Mr & Mrs Walter Lima  
43 Northaw Road East  
Cuffley  
Hertfordshire EN6 4LU

2<sup>nd</sup> March 2017

**RE: Objection to Amendments to Application by Mr & Mrs Anklesaria. - Ref:6/2016/1855/VAR Proposal to Removal of Condition 2 - Revised Plan drawings dated 17<sup>th</sup> January 2017)**

Side Elevation (South facing) Proposed

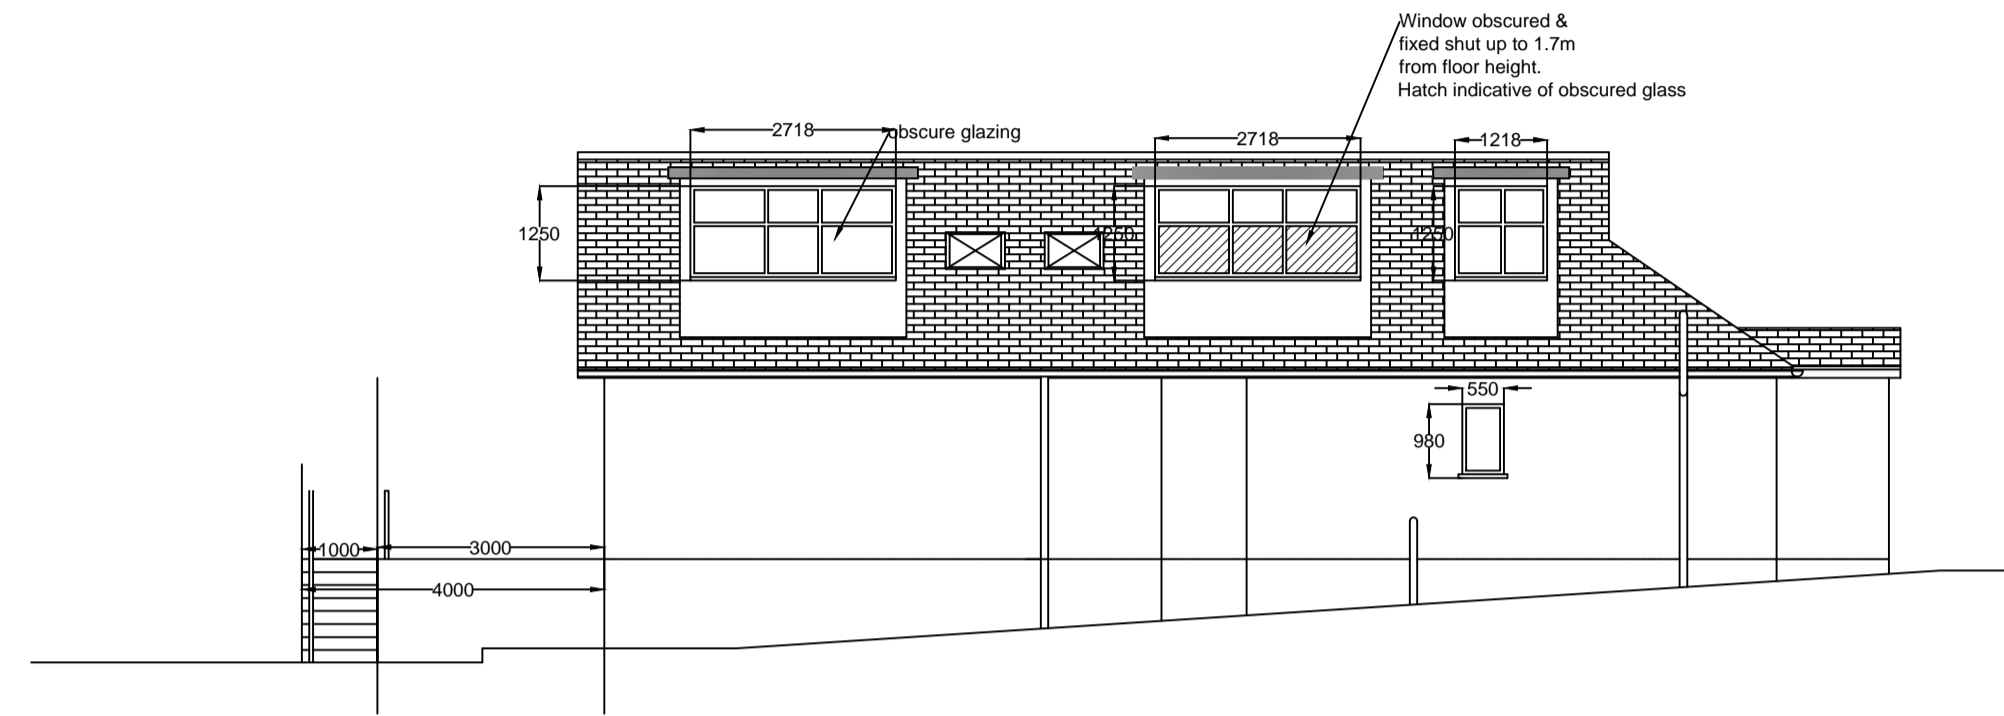
The drawings of the South Facing Elevation facing our property at No.43 in respect of these Elevations are misleading. Our property at No. 43 is North facing. The Council originally had to amend their report at the DMC Committee meeting of 18<sup>th</sup> August 2016, when this issue of elevations was considered.

Side Elevation (North facing) Proposed

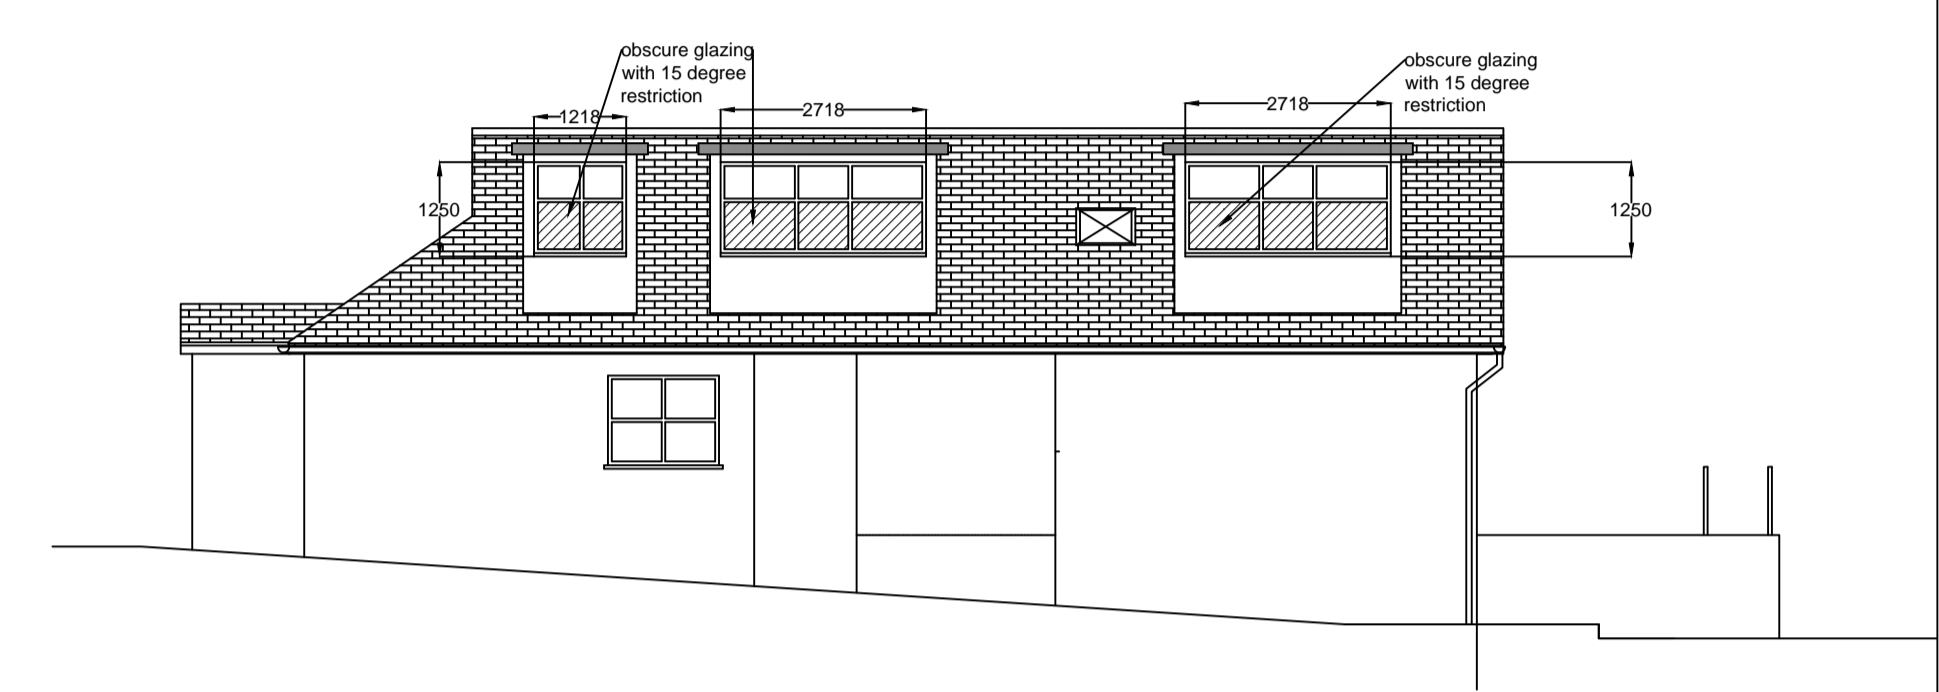
The Middle Dormer facing No.43 has four separate windows and not three as shown on the drawing. We have drawn the Council's attention to this breach of planning approval besides other blatant breaches.

North Facing Elevation windows

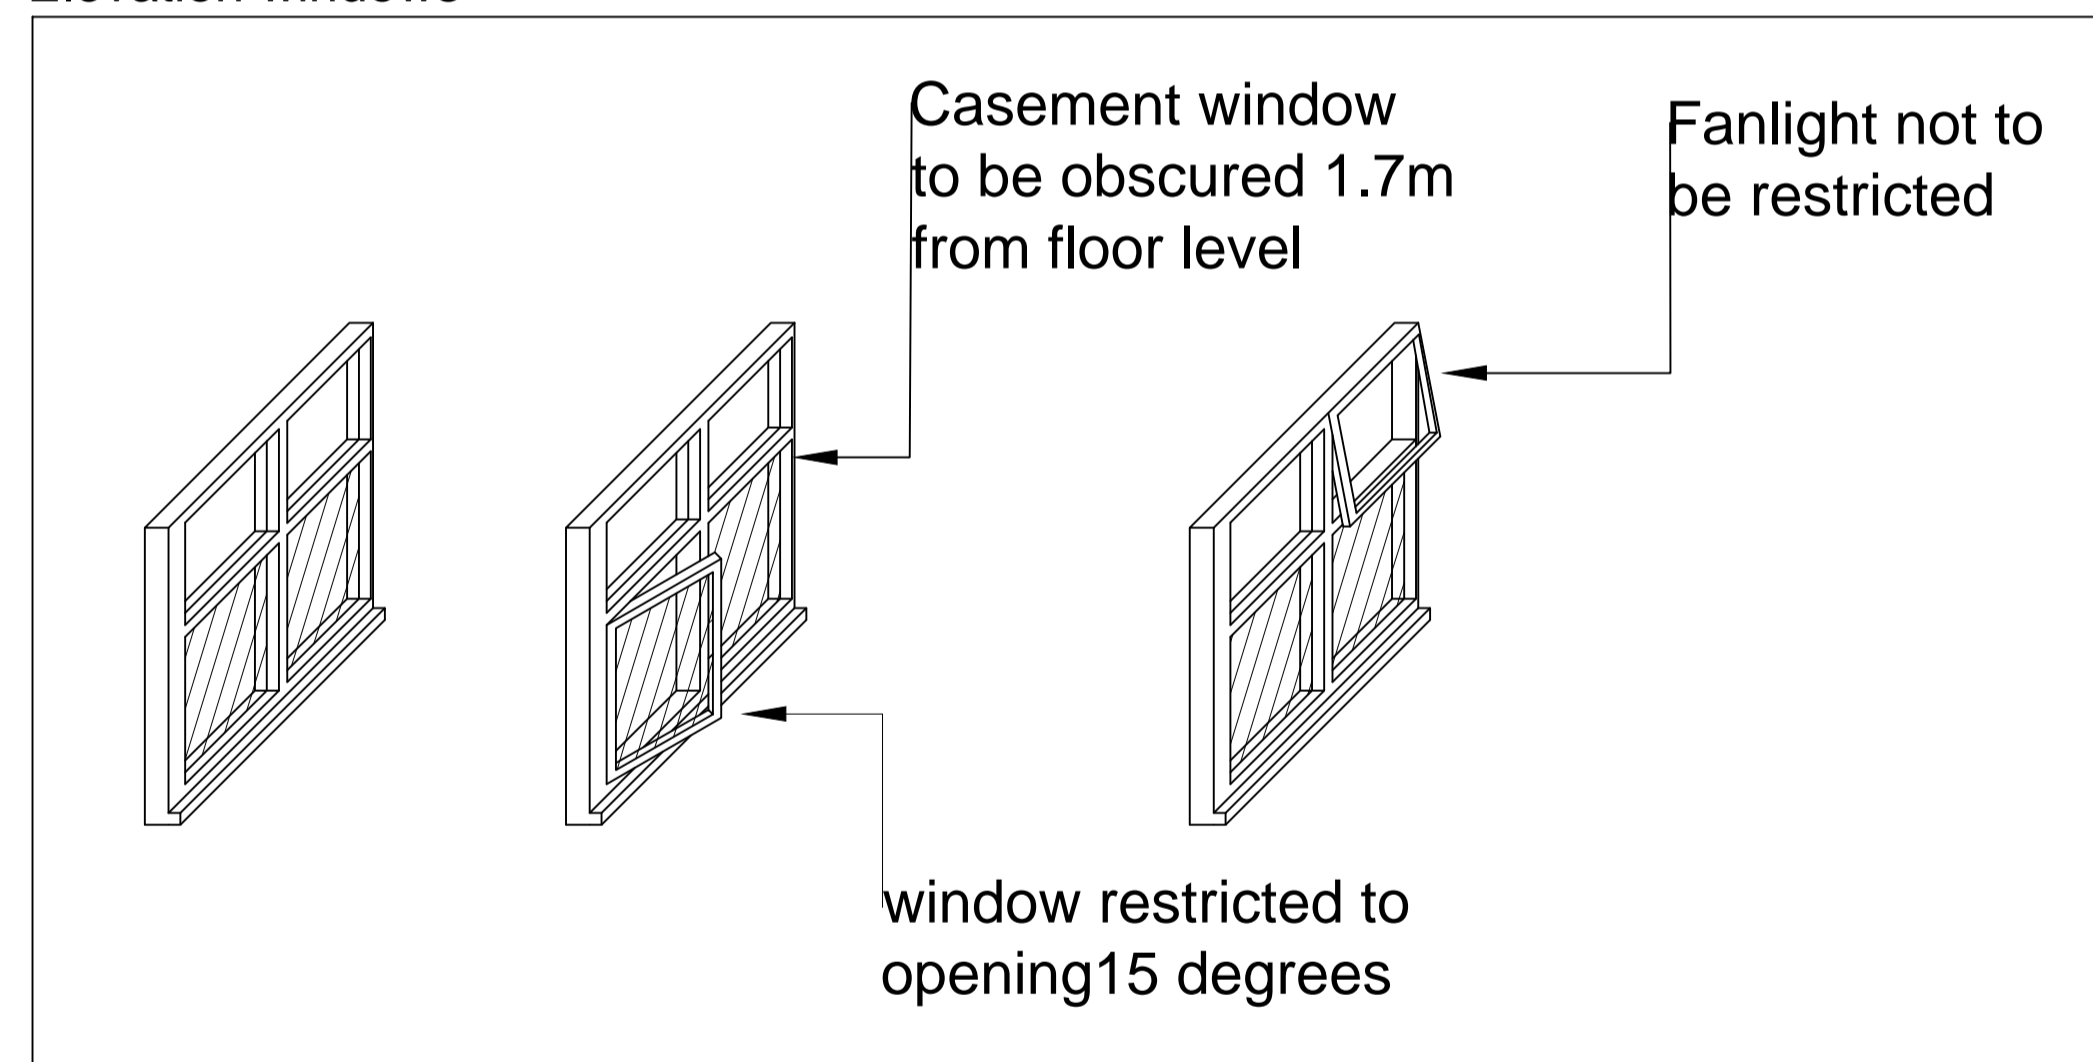
For the reasons stated above, we object the proposed Amendments to have partially glazed Dormer Windows facing our property at No. 43. Fixed obscured glass glazing is essential to protect our privacy, amenity and enjoyment of our property. The Council's decision on 18 August should be final.

All windows must be obscured in their entirety, partial obscuring up to 175cm for certain windows is not enough. **At 175cm from the floor a person 5ft 10" and above can easily look through** the non-obscured section. It is not an appropriate solution and any variation to the Committee's decision on 18 August is not acceptable.

Partial opening of the windows is not acceptable as future adjustments to the range of opening can be made by the present and future owners of No. 45 to open the windows in their entirety. Allowing any opening of the windows would destroy: (i) our right to Human Right to Privacy; and (ii) would render the obscuring of the window glass pointless. **Restricting the window opening is just as important as obscuring the glass.** The Council should enforce the decision of the committee immediately and avoid further Applications.
